**LAND EAST OF WOODWARD COURT, MIRFIELD
OBJECTIONS TO PROPOSED RESIDENTIAL DEVELOPMENT
BY BELLWAY HOMES ON HIGHWAY GROUNDS**

Kirklees Planning Application 2025/93355

ADDENDUM REPORT

August 2026 apk/2601/v1

Image 2.3 Proposed Hepworth Lane Site Egress

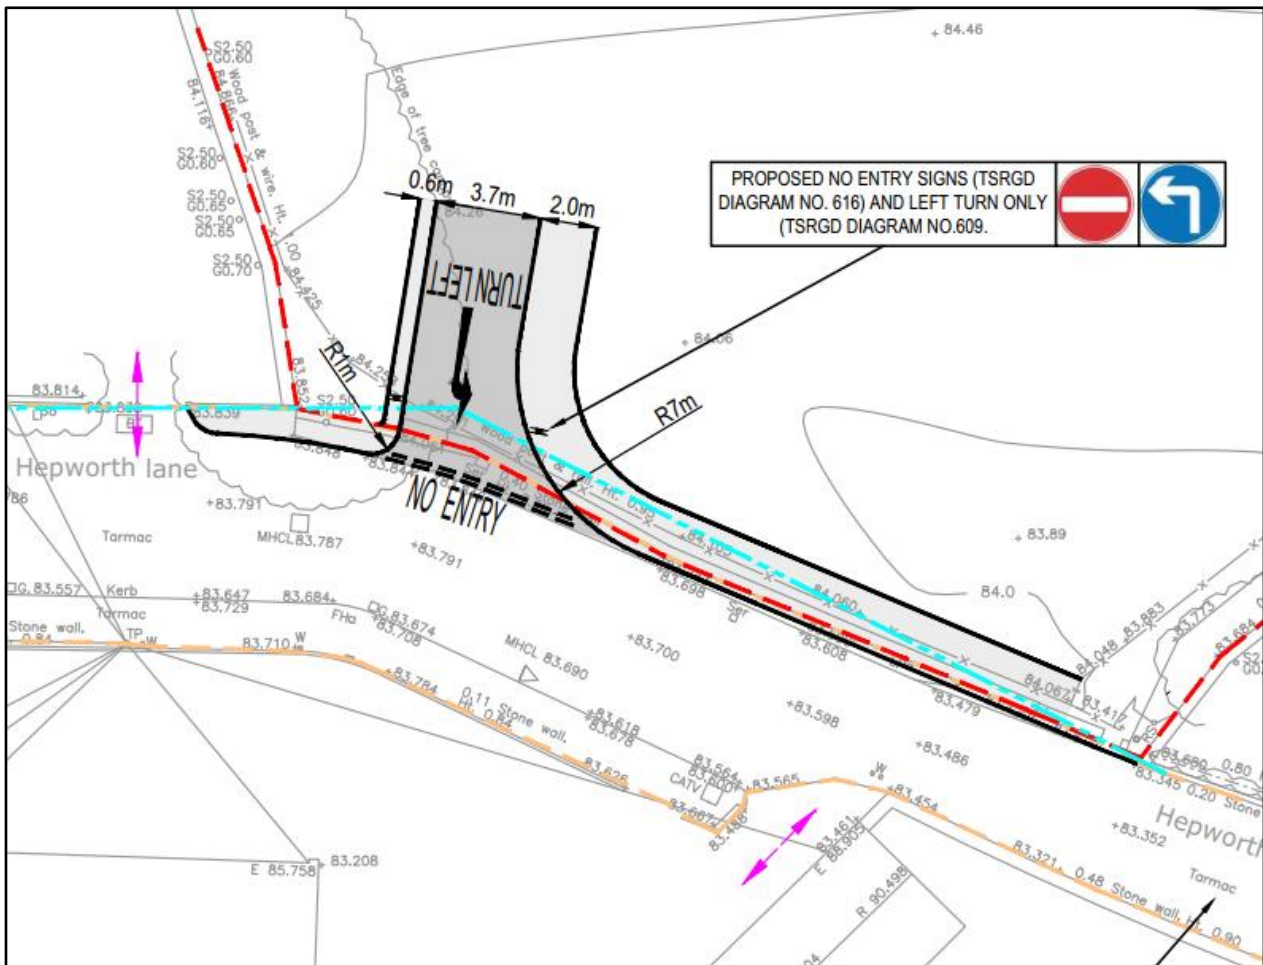
- 4.1.5 Bellway propose to allow traffic to exit the development onto Hepworth Lane, with cyclists and pedestrians also allowed to enter the site at this point. The egress includes a 2.0 metre footway to each side to provide for pedestrian movement, site consistent with normal highway standards. To the west of the egress a new, A sub-standard 1.2 metre footway is proposed on the nearside of Hepworth Lane between the egress and Hepworth Close. To the east of the egress a short section of new 2.0 metre nearside footway is proposed from the egress to the eastern boundary of the site.

- 4.1.6 By proposing a 2.0 metre footway within the site, Bellway recognise this to be the appropriate standard for footway provision (consistent with table 1 of the adopted Kirklees Highway Design Guide and guidance provided in Manual for Streets). A 2.0 metre footway allows all categories of pedestrian user to pass, (including prams, pushchairs and wheelchairs) and is therefore recognised as the normal standard. At 1.2 metres, there would be insufficient width for a pedestrian to pass a pram, pushchair or wheelchair, such that the pedestrian would likely step into the road to pass.

- 4.1.7 Even with the proposed works described in the paragraph above, footway provision on Hepworth Lane would remain well below the normal standard such that the proposals which promote increased pedestrian activity on Hepworth Lane should be considered unacceptable on road safety grounds. It should also be noted that there is no footway on the one-way section of Hepworth Lane to the west of the egress and similarly to the east of the egress there is no footway provision site boundary through to Shillbank Lane confirming that increased pedestrian use of Hepworth Lane would be unacceptable from a road safety viewpoint.

This is a narrow lane with a serious pinch point near the proposed exit from the estate.

The narrow footway on the northern side of Hepworth (1.2m) is not much use to parents with buggies or the disabled. It will still require pedestrians to step into the lane if passing others. It may be safer to walk in the road than to risk falling into it.
